**Application ref: 6/2015/2340/HOUSE**

**Proposed development at 8 Wilkins Green Lane, Hatfield AL10 9RT  
Proposal: 2 storey extension, conservatory and modifications to roof**

Drawing Title
Proposed Elevations

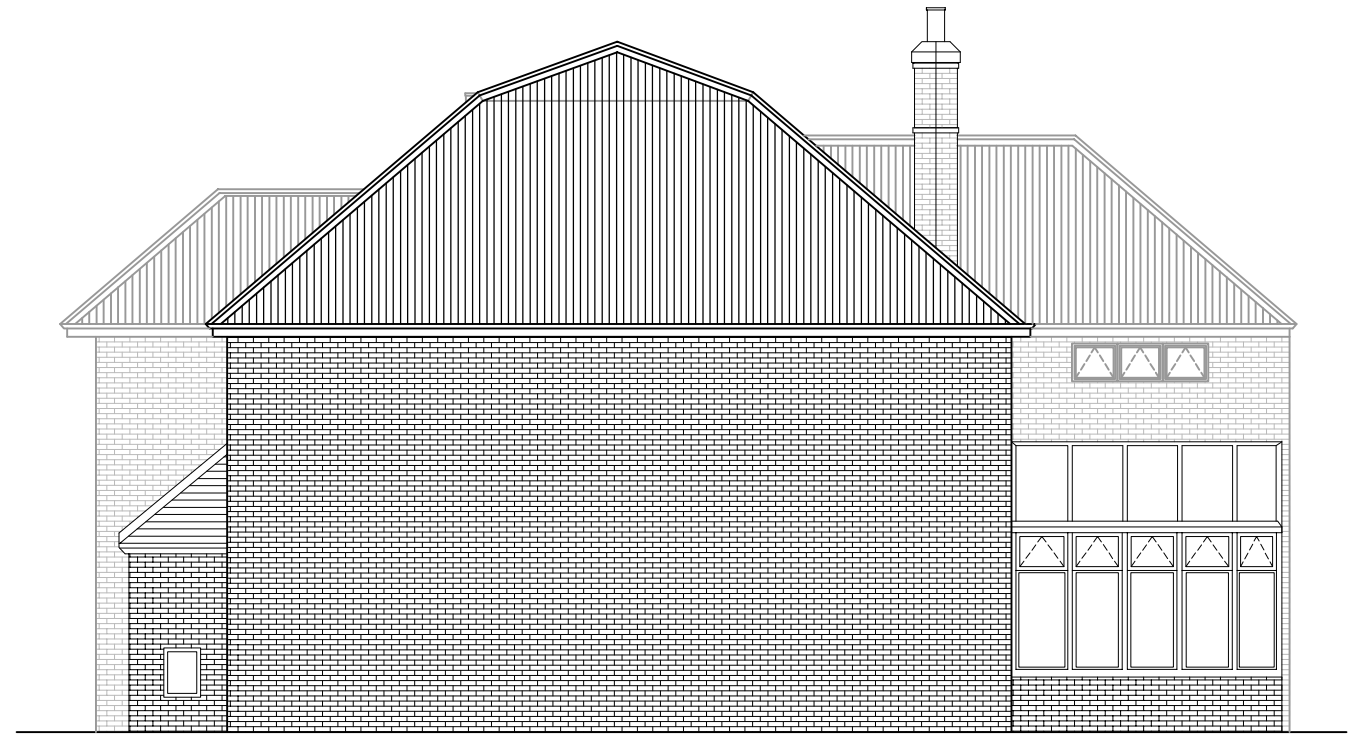
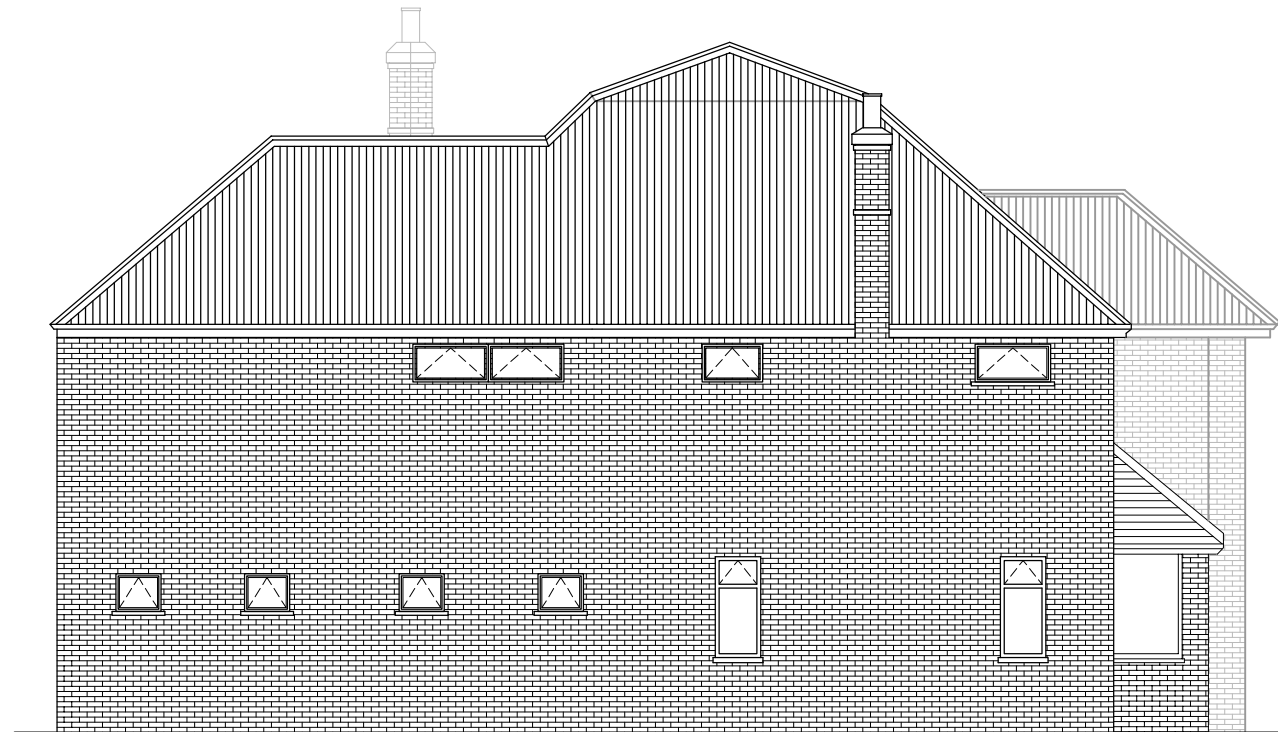
1. The proposed development will restrict light to the following rooms of our house:
  - (i) Our daughter's rear bedroom. The side window currently allows in light, but this will be very much reduced.
  - (ii) The middle downstairs reception currently used as a living room/TV room.
  - (iii) The downstairs shower room
  - (iv) Our kitchen although this to a lesser extent than the other

three rooms, as the kitchen is set further back from the extensive outside wall of the proposed new development.

(i) The outlook from our daughter's room's side window will be straight into a brick wall just a few feet away.

(ii) The outlook from two windows in our son's bedroom will be towards the large brick exterior wall of the proposed development, albeit further back than from our daughter's bedroom.

(iii) The outlook from our kitchen will be straight onto the large exterior brick wall of the proposed new development. Some of the wall may be obscured by the tall hedge but there will still be a considerable impact on the visual amenity.

We would have no objection if the planning application were amended to be a single storey extension and conservatory as this would not adversely affect our property in the same way as the present application does.
